**DEVELOPMENT REVIEW BOARD  
ACTION SHEET**

33 **Project #: 1003428**  
04DRB-00716 Minor-SiteDev:Plan  
BldPermit

JOHN K. KLEE agent(s) for INTERSTATE DEVELOPMENT LLC request(s) the above action(s) for all or a portion of Lot(s) 54, **ALAMEDA BUSINESS PARK**, zoned SU-2 IP-EP, located on PASEO ALAMEDA NE and VISTA ALAMEDA NE, containing approximately 1 acre(s). [REF: DRB-98-223, 1000624 (Master Plan)] (Deferred from 5-19-04) (C-16) **THE SITE PLAN FOR BUILDING PERMIT WAS APPROVED WITH FINAL SIGN-OFF-DELEGATED TO PLANNING AND TRANSPORTATION FOR PART OF A 6-FOOT LANDSCAPE BUFFER ON THE EAST SIDE, SOLID WASTE'S SIGNATURE, RADIUS AT ENTRANCE TO BE 15 FEET, AND STANDARD NOTE FOR CONSTRUCTION OF DRIVE PAD.**

RE: Lot 54, Alameda Business Park/SPBP

STD. REFUSE ENCLOSURE
SCALE: NTS

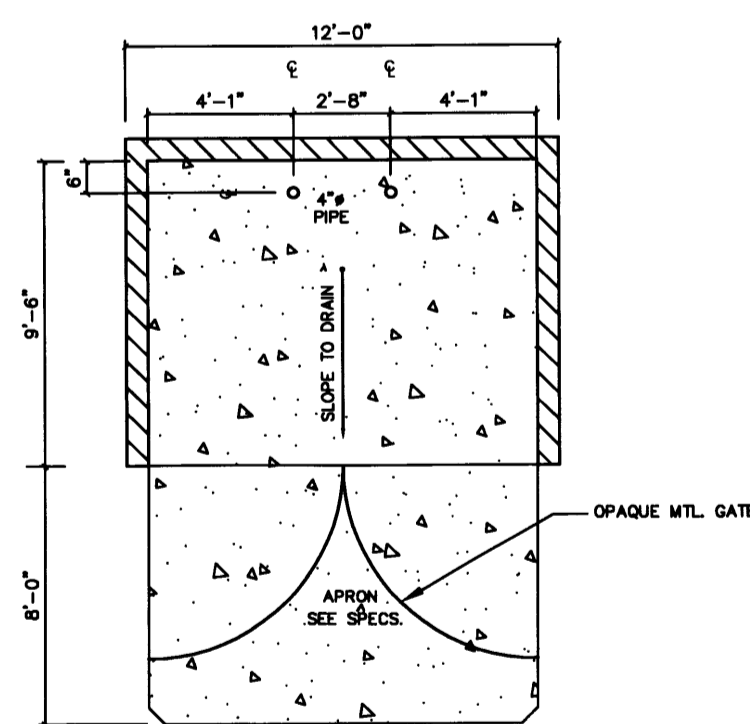
8. The elevation drawing for the refuse container & enclosure is missing.

LANDSCAPE PLAN
SCALE: 1" = 10'-0"

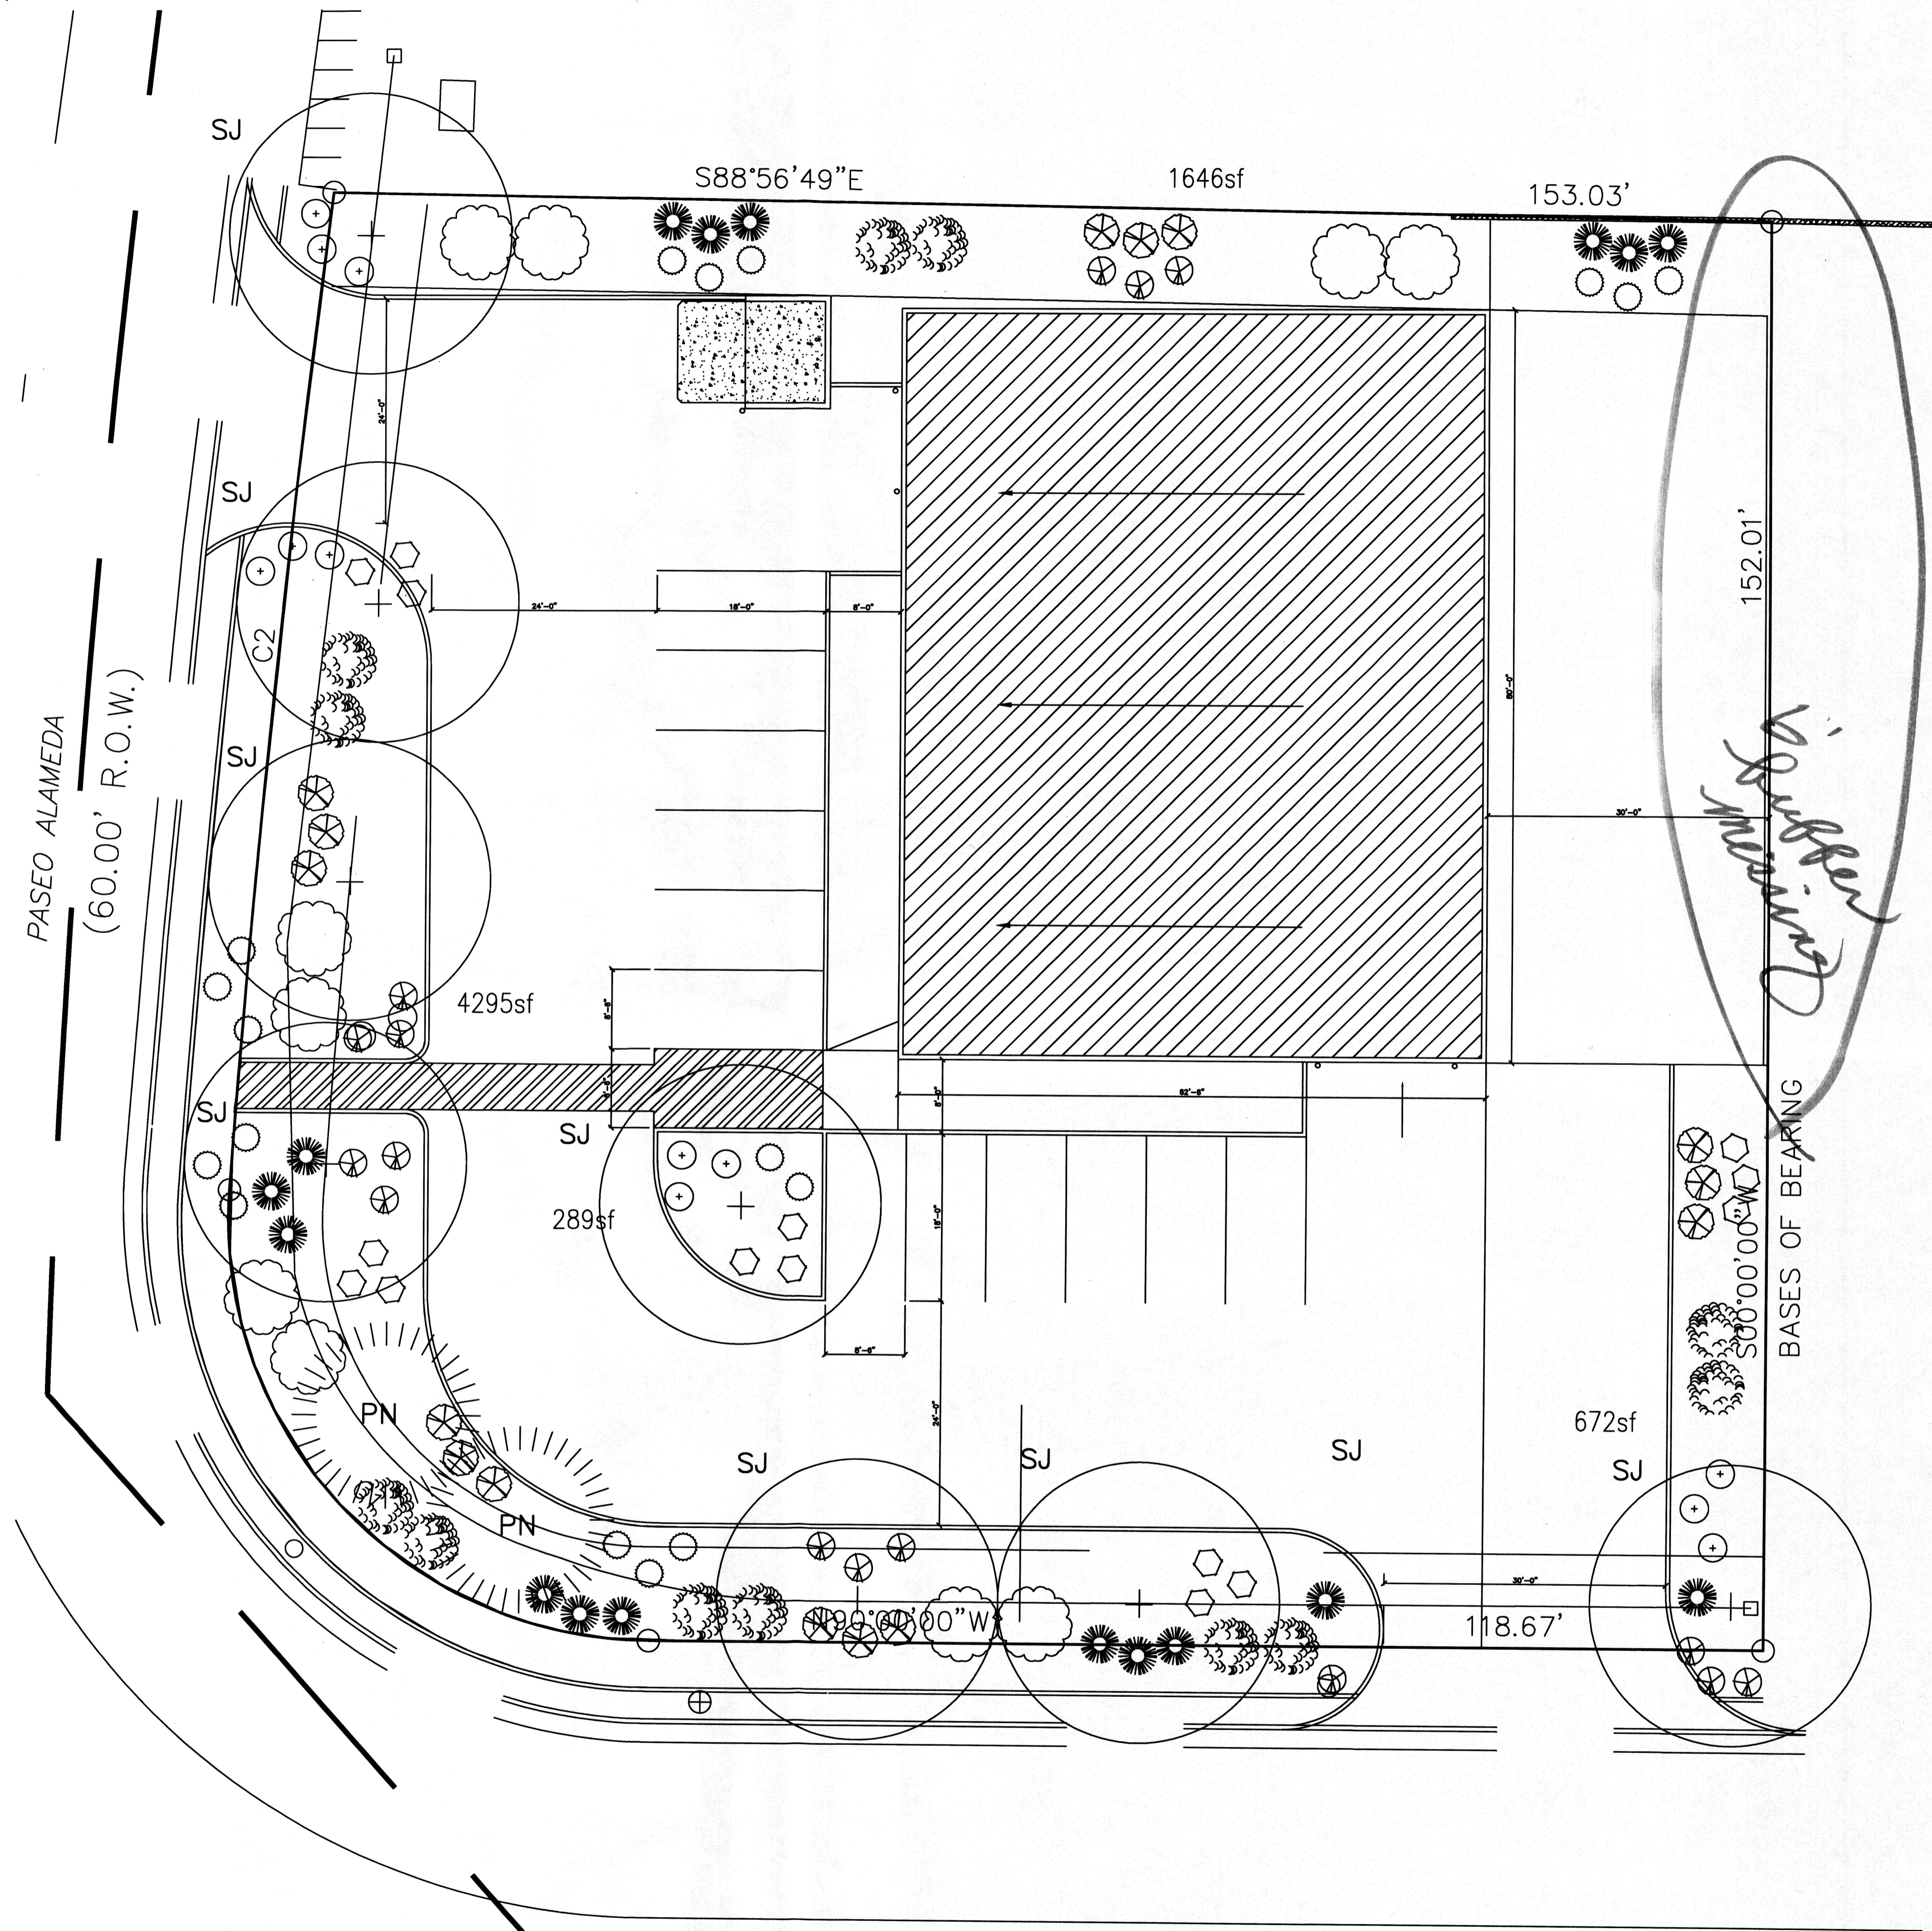
<sup>OK</sup>  
12. Landscape Plan: The property lines should be clearly delineated. The existing & proposed easements are missing from this sheet. The type of irrigation system to be used should be described. The square footage of each bed is needed.

The North I25 Sector Plan requires a 6' wide landscape strip along the rear of the property. Our guess is that the front of the building faces west. Therefore, the east side should have this buffer. It is not continuous across the length of the rear property line. East side has to have 6' buffer  
Continuous as well.
